Application for a non-material amendment following a grant of planning permission.

Number	10
Suffix	
Property name	
Address line 1	St Peters Close
Address line 2	
Address line 3	
Town/city	Clayton Le Dale
Postcode	BB1 9HH

Proposed erection of a single storey rear extension and a two storey side extension.	
Reference number:	3/2018/1102
Date of decision	24/01/2019

5646 - 02
REV
F

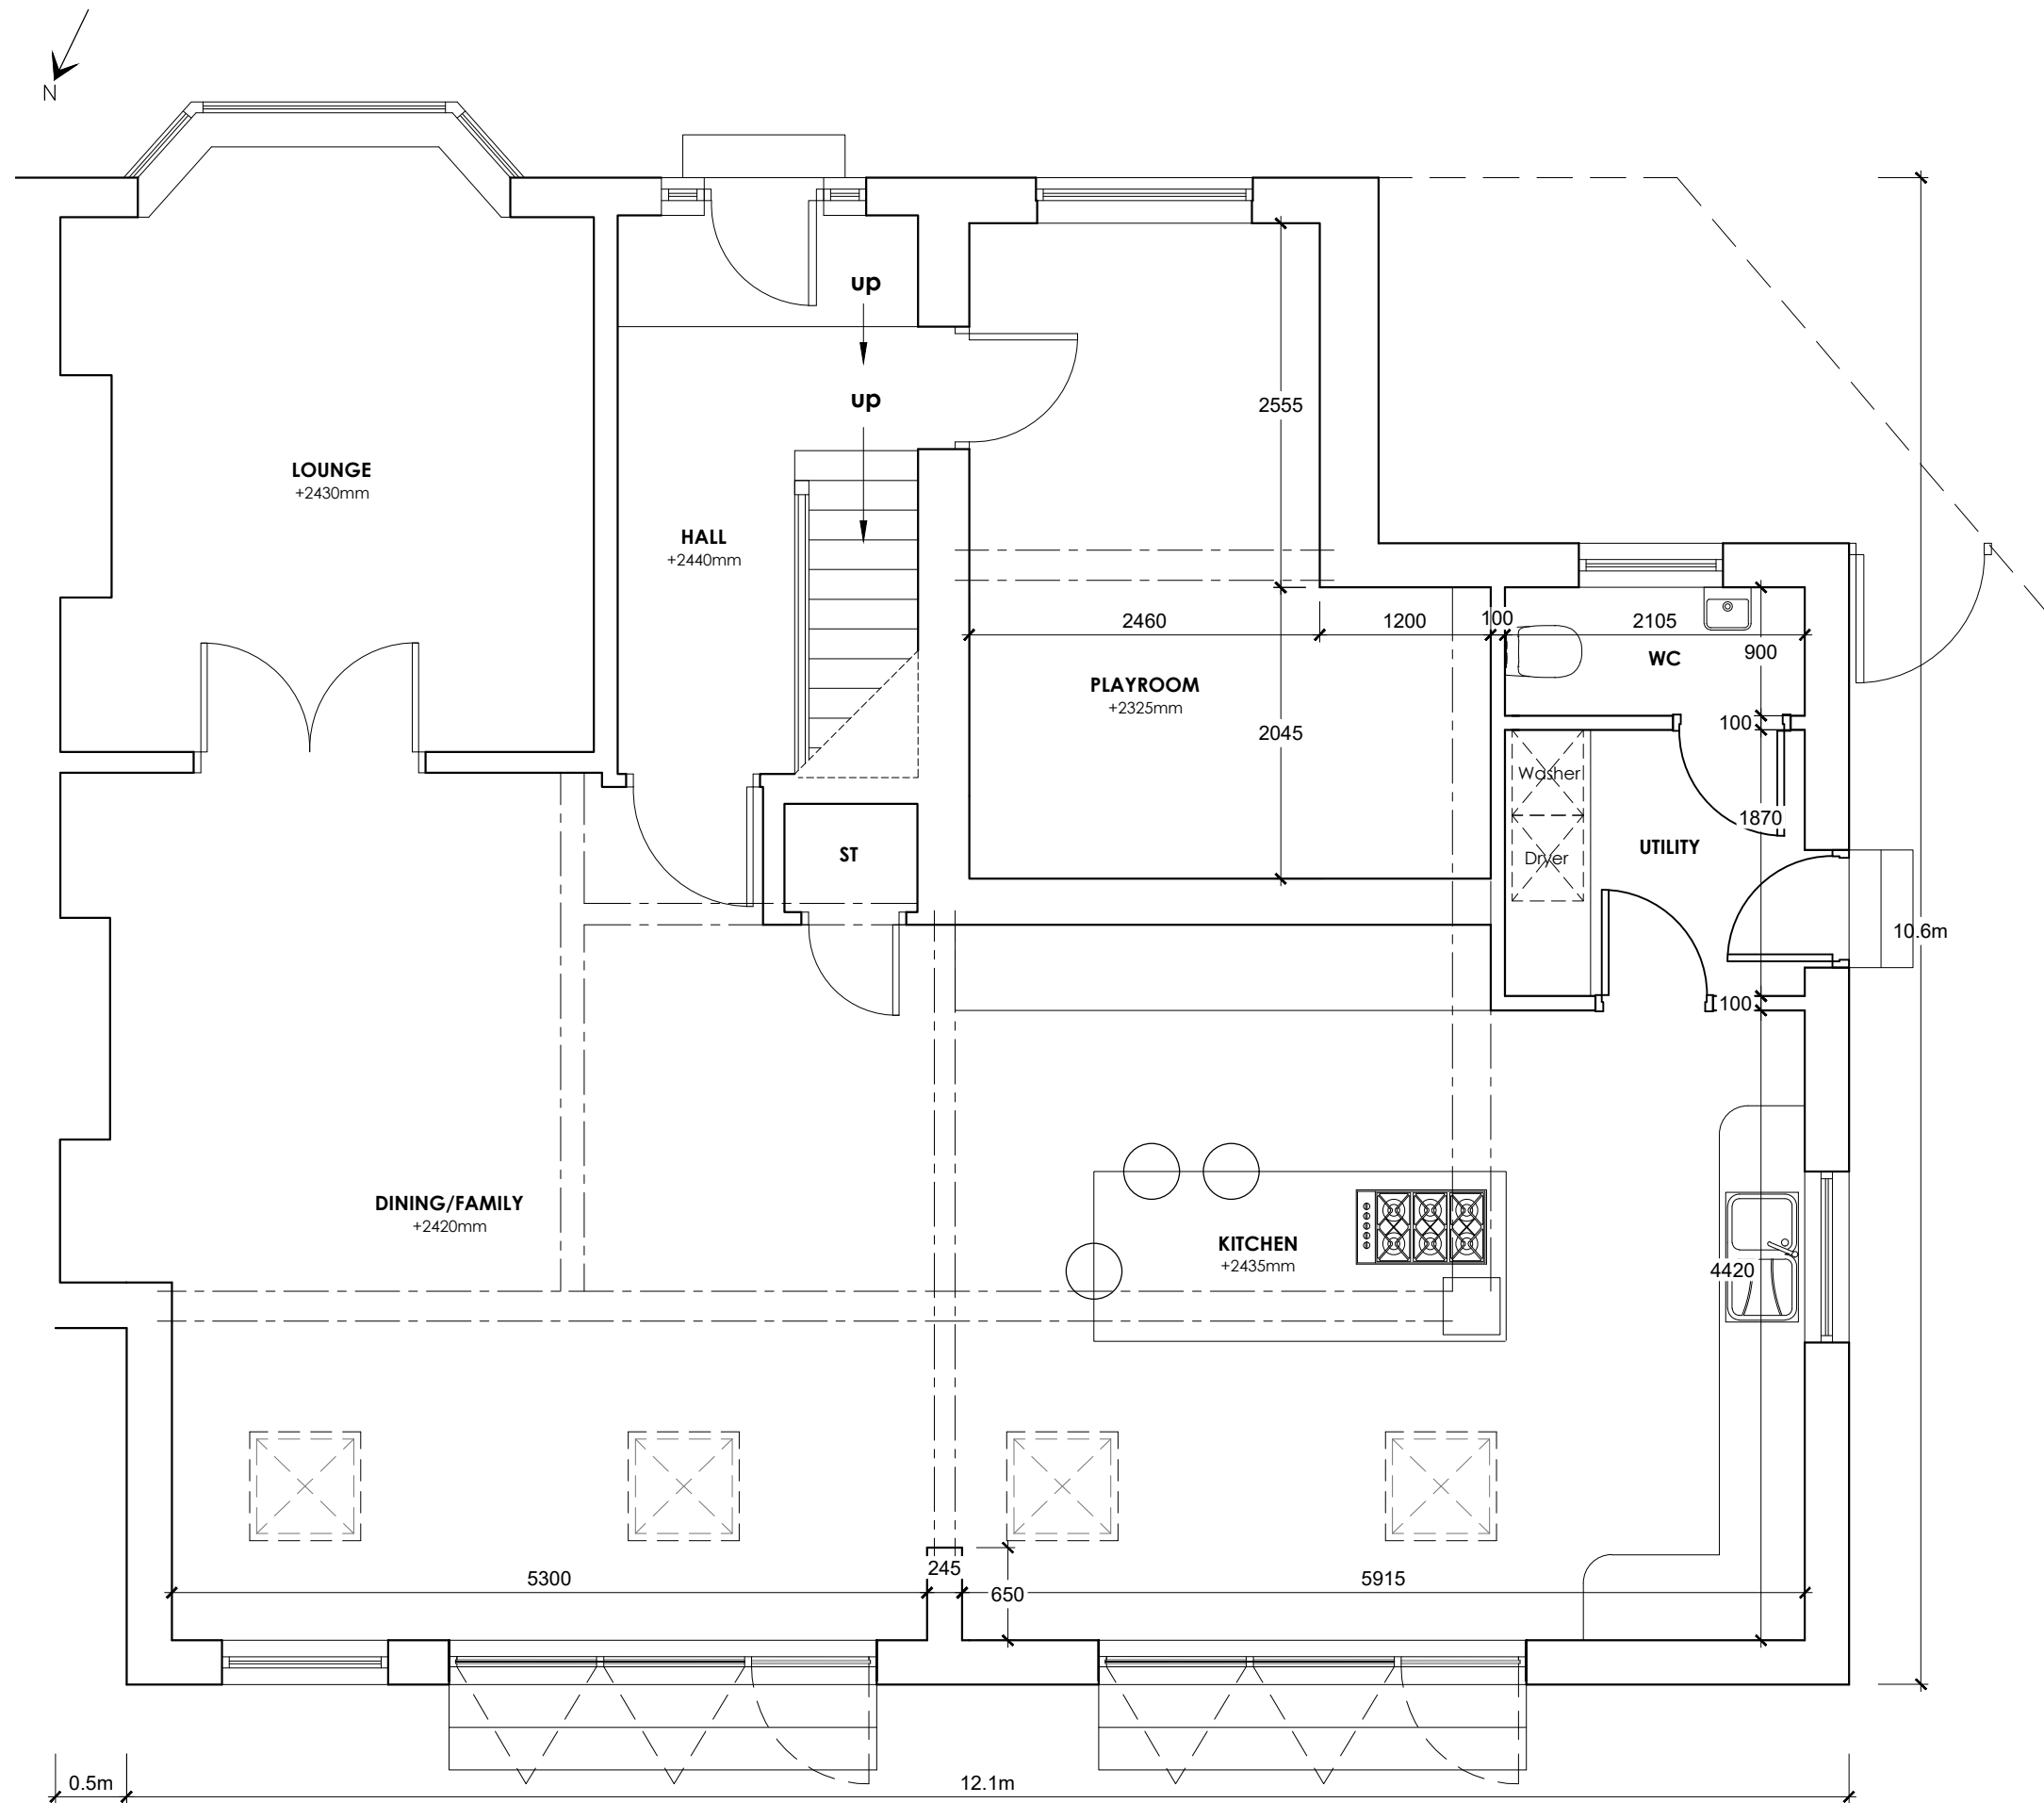
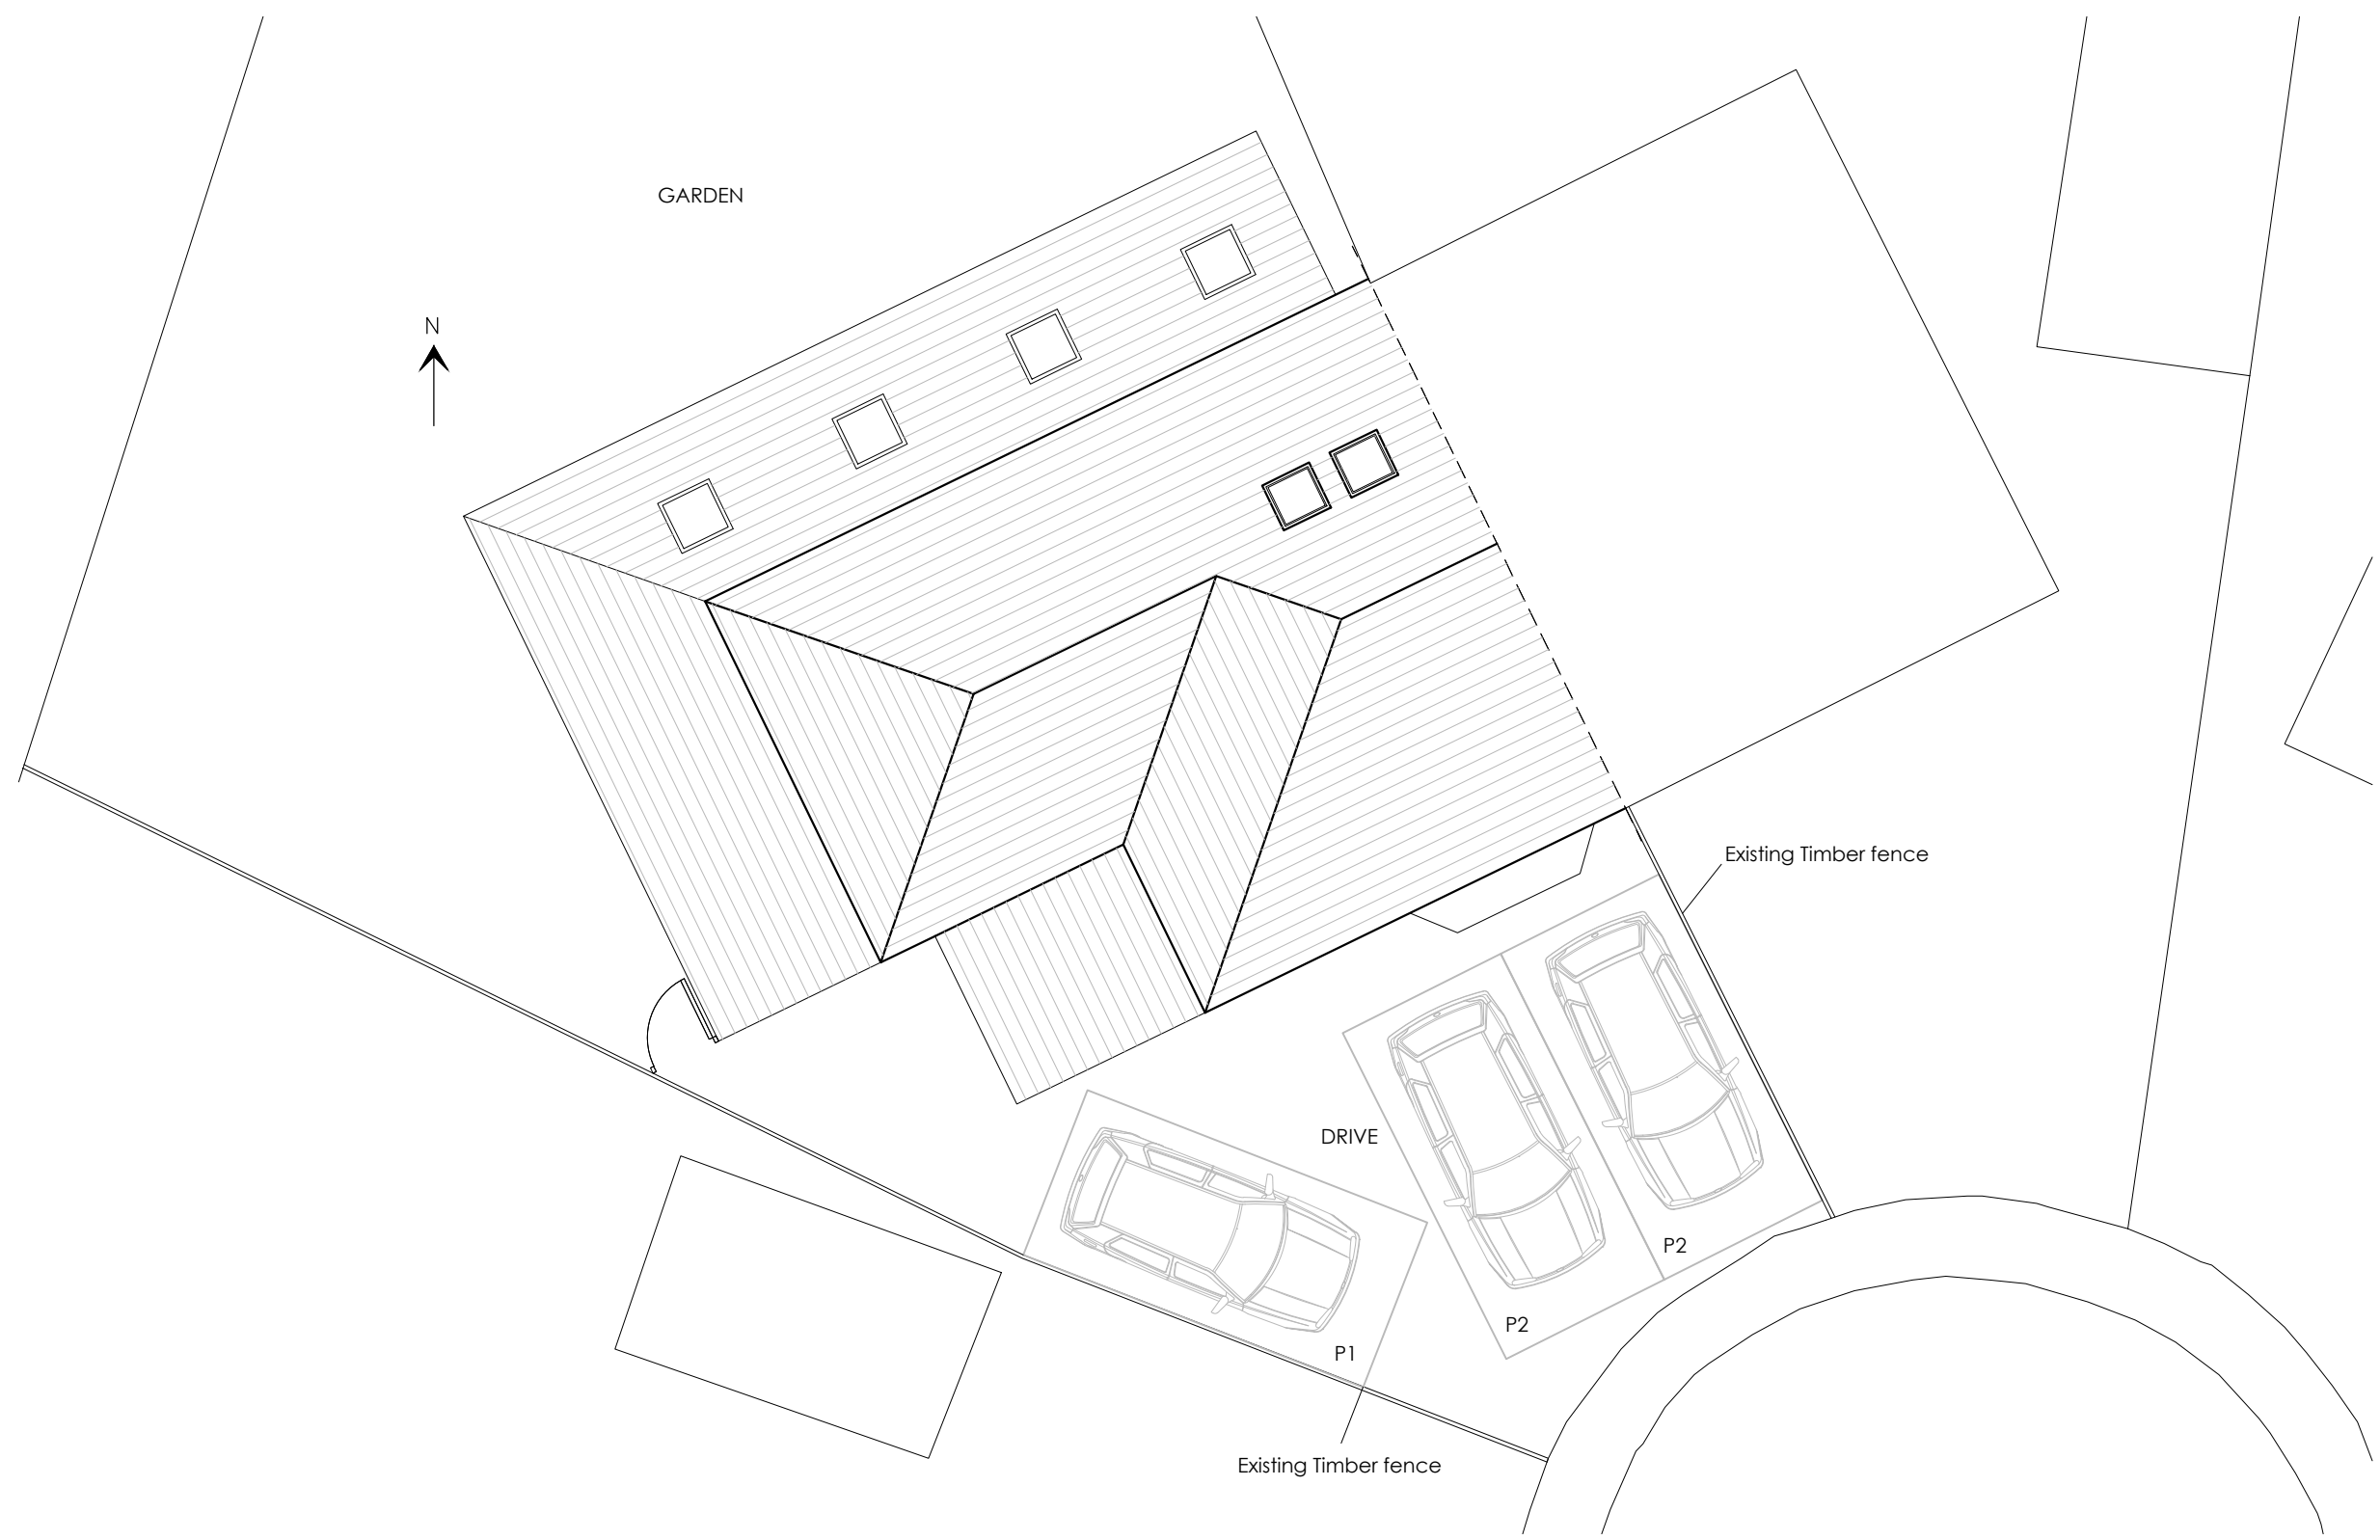
- Removing a proposed window to the North Elevation.
- Incorporating an additional bi-folding door to the North Elevation.
- Increasing height of the proposed window to the North Elevation.
- Re positioning a proposed window to the West Elevation.
